## Appeal Decision

**Appeal Ref: APP/R5510/W/25/3373647**

**123A Central Avenue, Hayes, Hillingdon UB3 2BS**

- The appeal is made under section 78 of the Town and Country Planning Act 1990 (as amended) against a refusal to grant planning permission.
  - The appeal is made by Mr J Singh against the decision of the Council of the London Borough of Hillingdon.
  - The application Ref is 78009/APP/2025/1540.
  - The development proposed is alterations and extension to existing part single/part two storey side extension to create new end of terrace dwelling with associated amenity, parking and bin storage.
-

Drawing Title: Proposed Site Plan Client: Jarnail Singh Date: 03/05/2025 Drawn By: SY

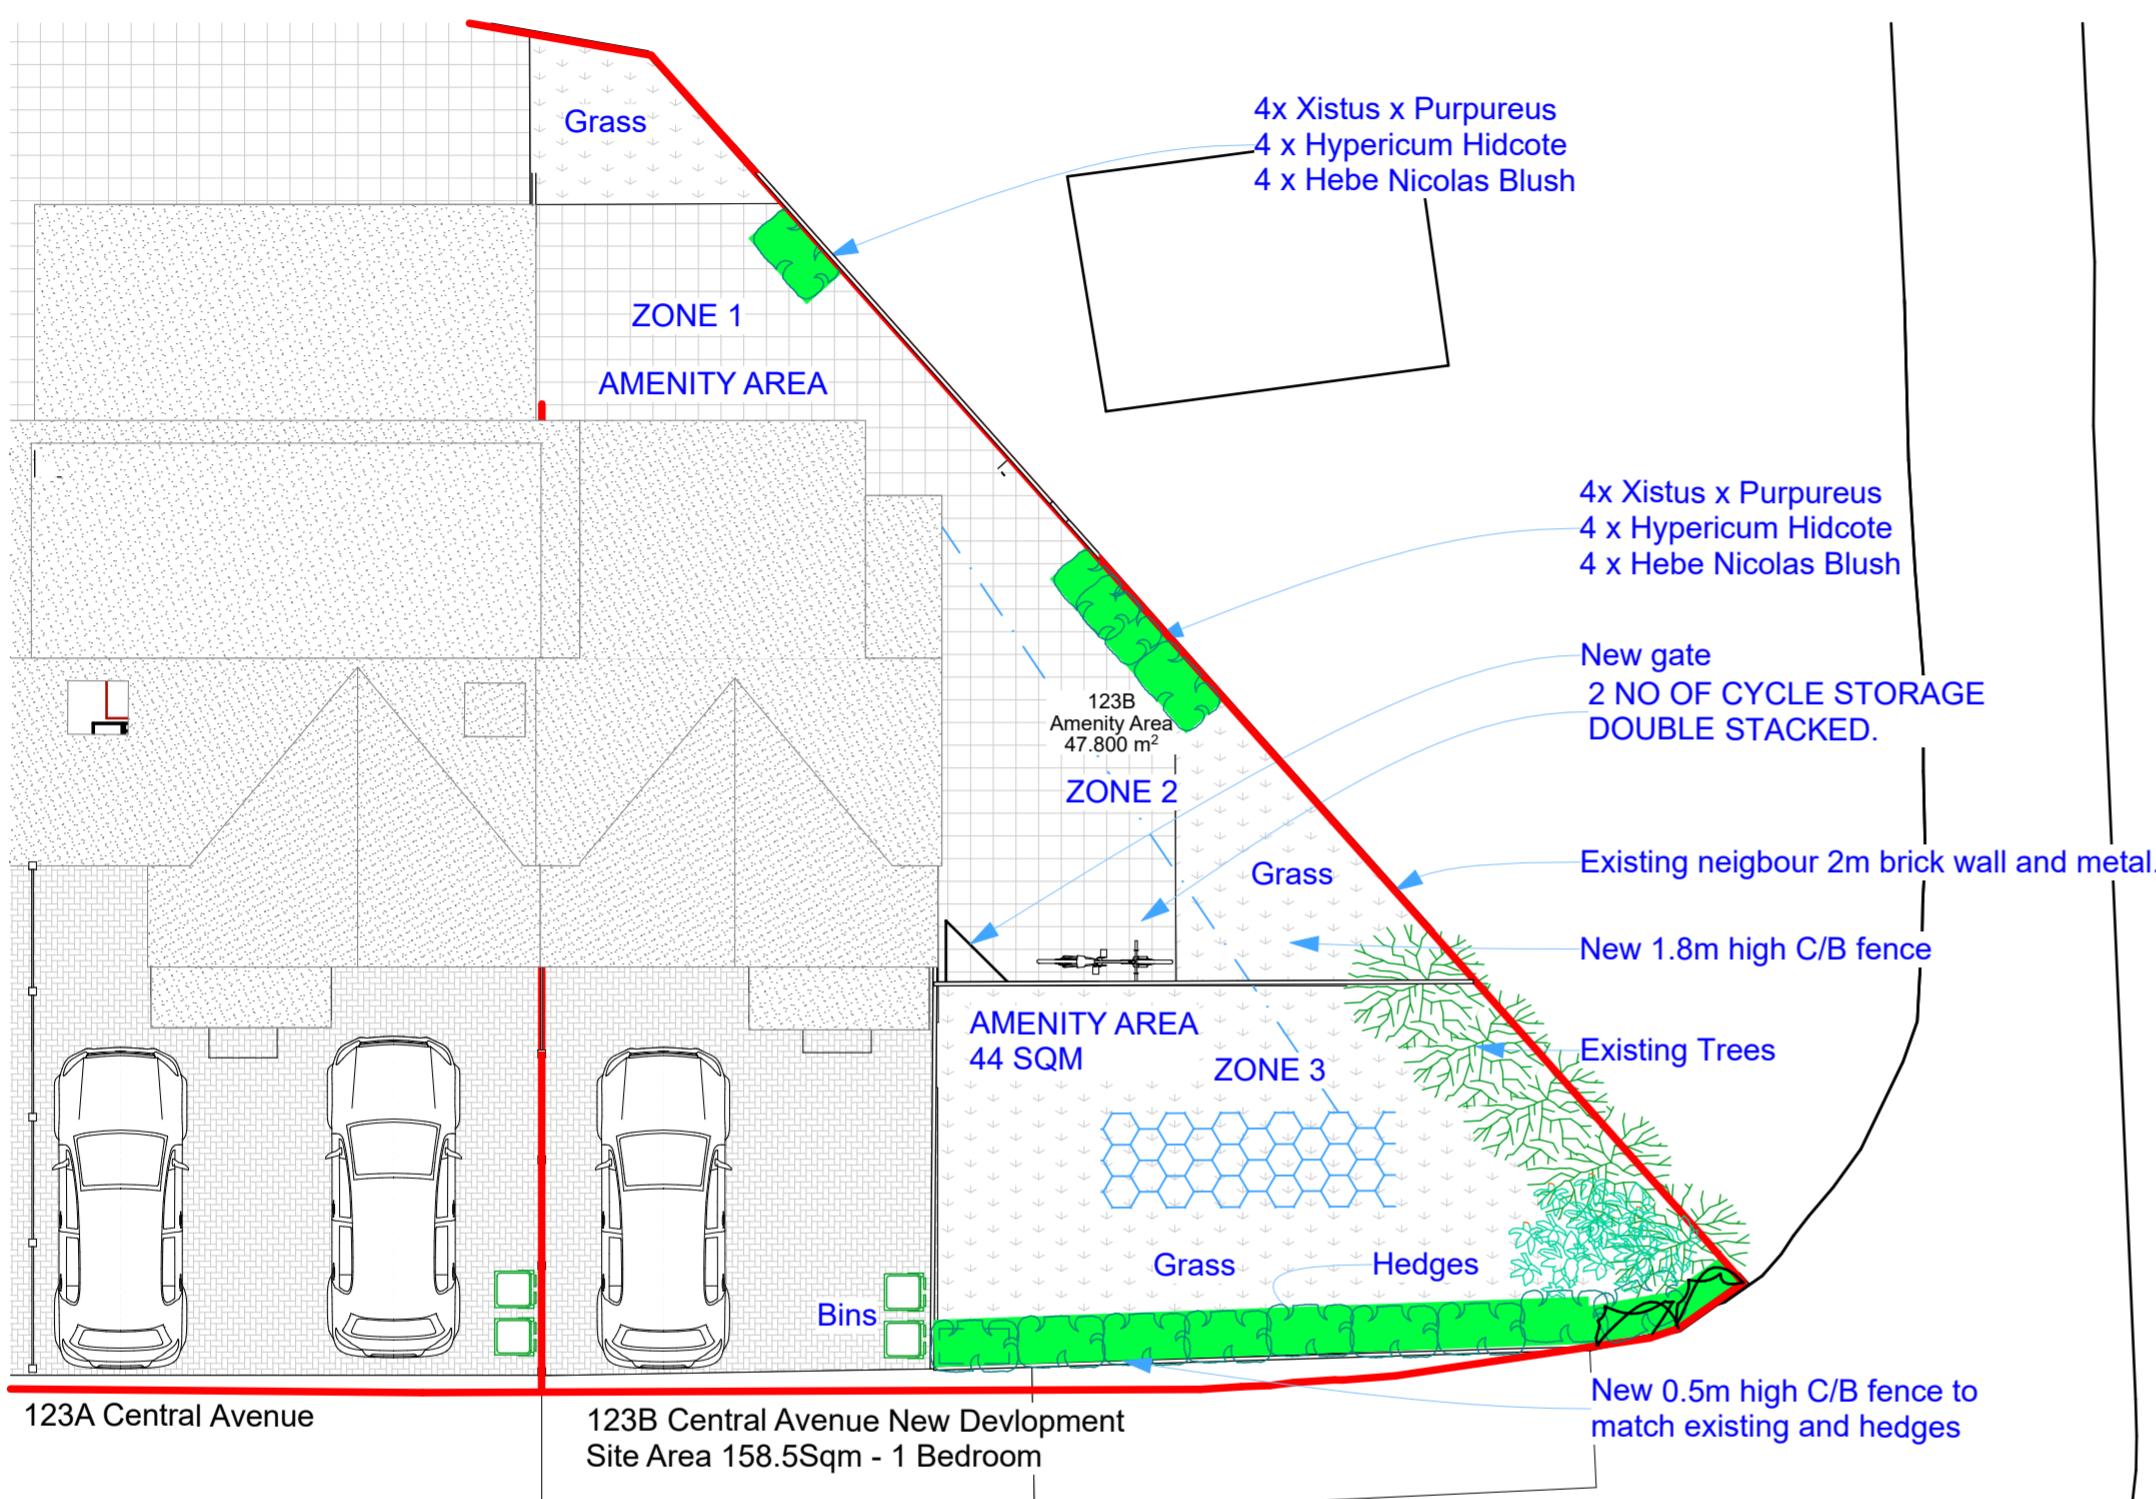
13. The subdivision of the plot of No.123A would reduce its garden amenity space. The resulting garden areas for No.123A and the proposed dwelling would each be very small, contrary to the general pattern of larger rear gardens found at neighbouring sites. Irrespective of variation in the size of side gardens, the proposal would appear cramped within its plot by comparison to its neighbours. This would undermine the contribution the site makes to the generally consistent plot sizes and layouts within the ASLC.

17. The total area of private amenity space as proposed would exceed the minimum of 40sqm required by Policy DMHB 18 of the Local Plan DMP. The attractiveness of the rear amenity area (broadly labelled Zone 1) would be somewhat compromised by its shape, which would decrease in width given the splay of the site boundary together with being confined by buildings and boundary walls on all sides.

18. However, further amenity space would be provided to the side of the plot (Zone 2) with convenient direct access from a door at the side elevation. The floor area appears to be greater than what was proposed in the previous appeal scheme and its design better facilitates access between the side and rear parts of the site. This larger area could be used for a broad range of outdoor domestic activities, whilst proposed fencing would ensure privacy of its users. Despite the shortcomings of the rearmost area when considered in isolation, overall there would be good quality and useable private amenity space for future occupiers of a sufficient size.

Drawing Title: Proposed Ground Floor Plan Client: Jarnail Singh Date: 03/05/2025 Drawn By: SY  
Status: Plans Proposed Scale: 1:500, 1:50, 1:100@A2 Project No: 1037 Drawing No: 1037-13 Rev: 08  
Plans Proposed

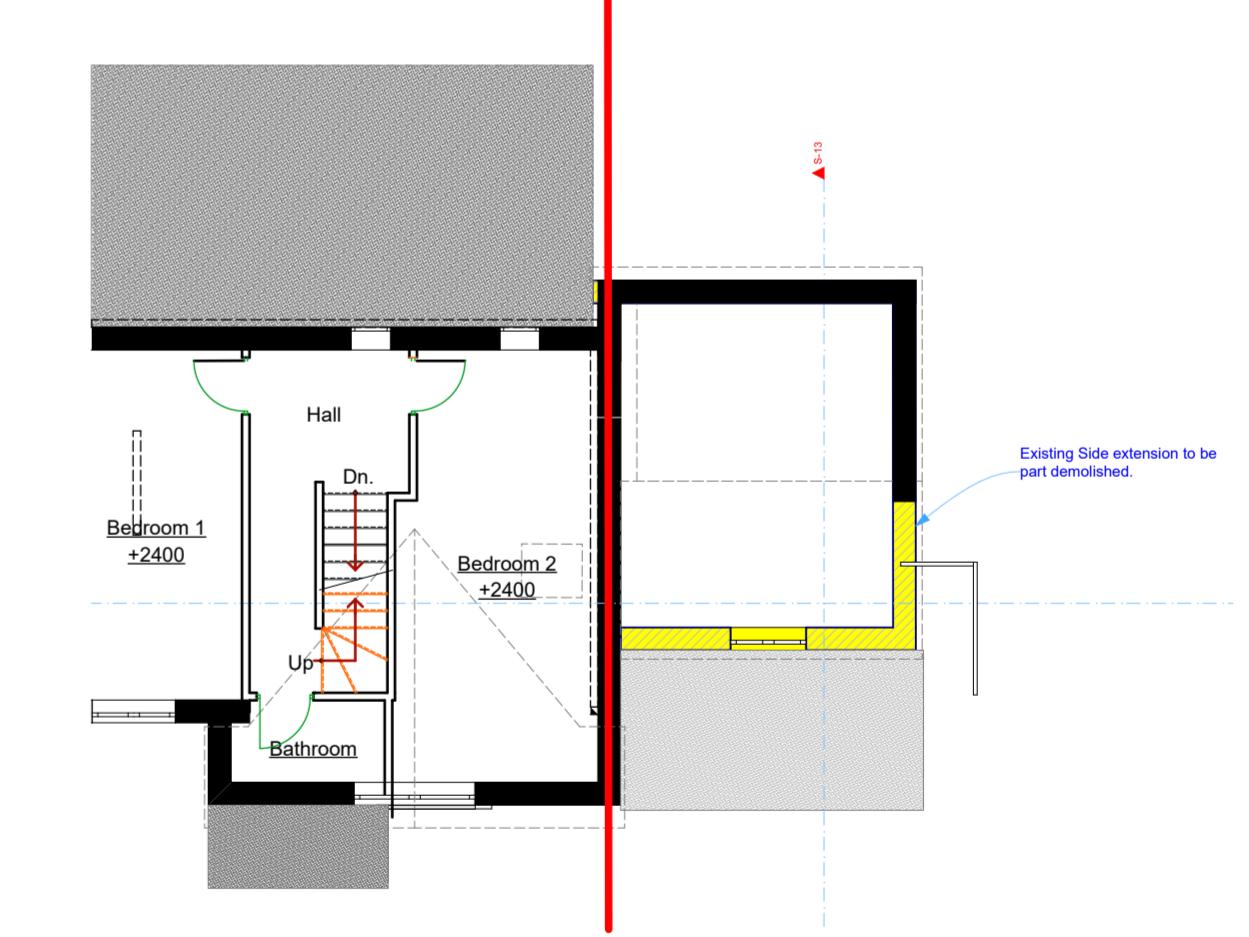
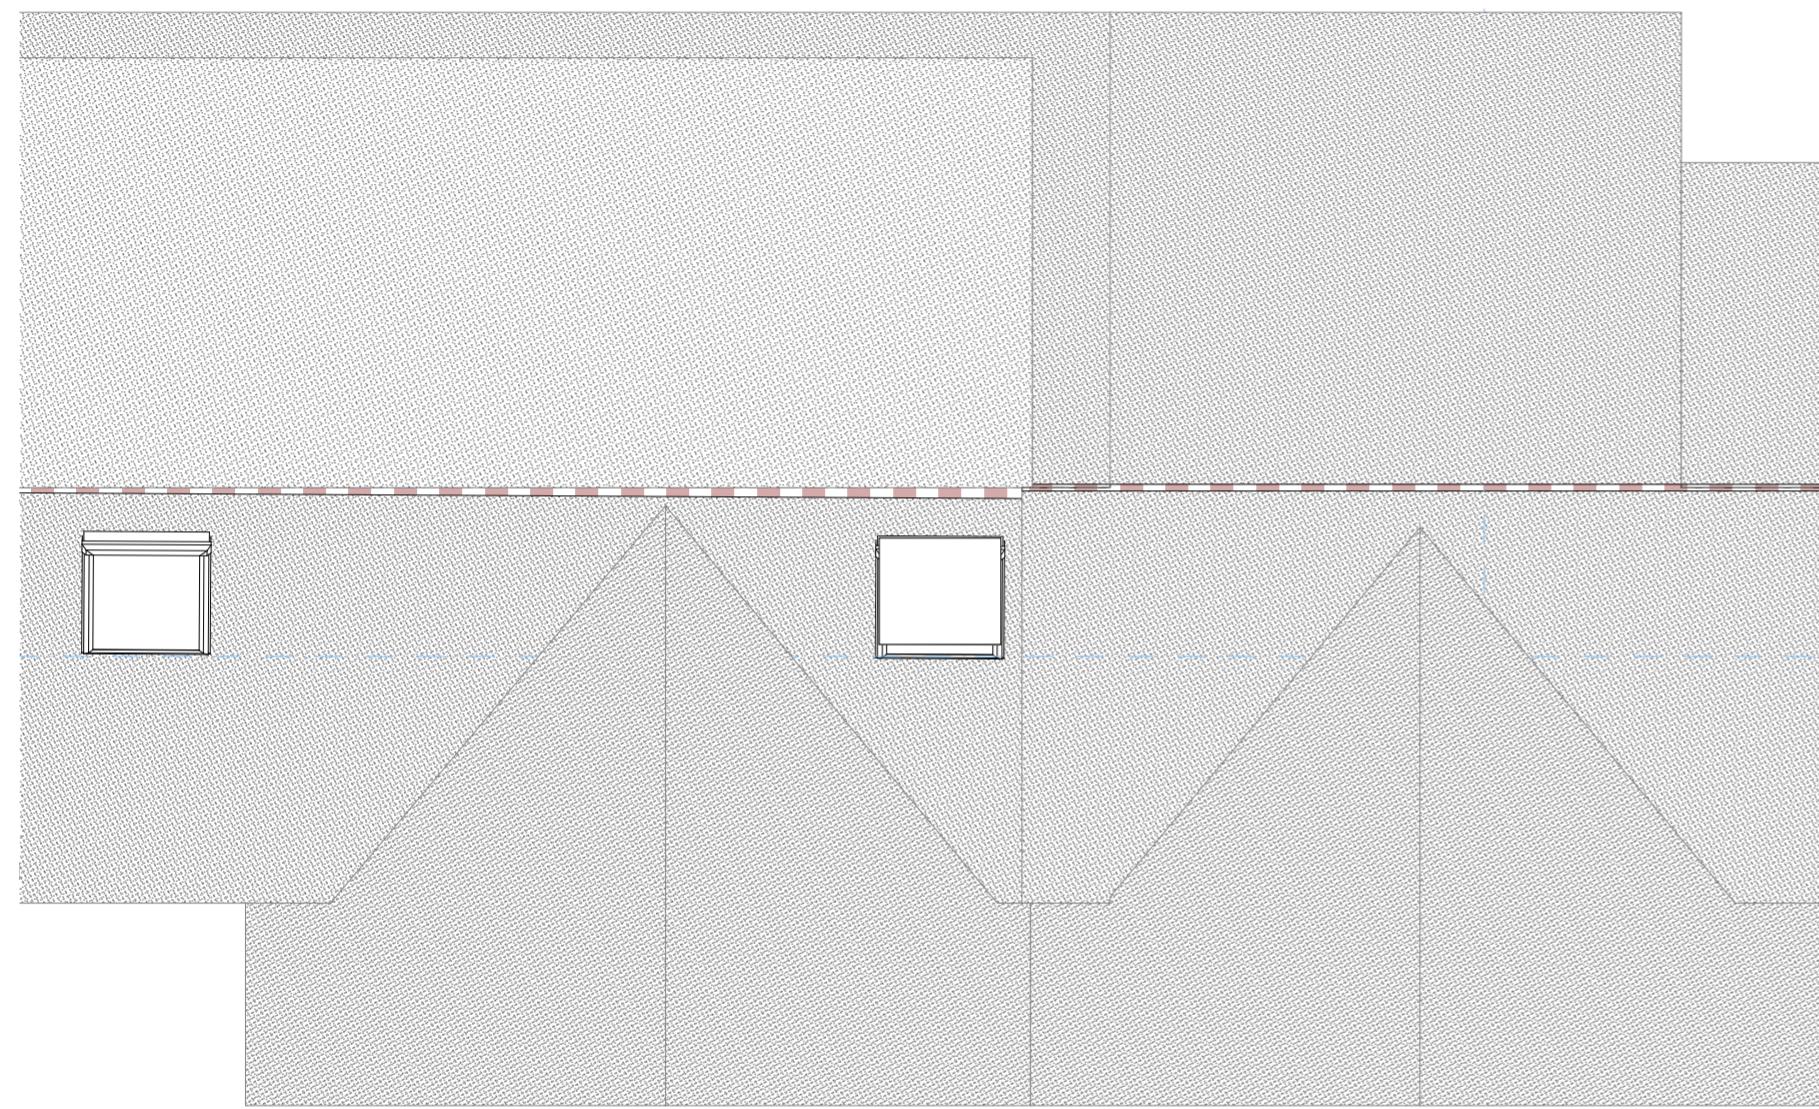
### Preliminary Matters

this relationship. Despite a notionally small increase in width, the further erosion of the gap between buildings would undermine the site's remaining contribution to a spacious layout, harming the significance of the ASLC.
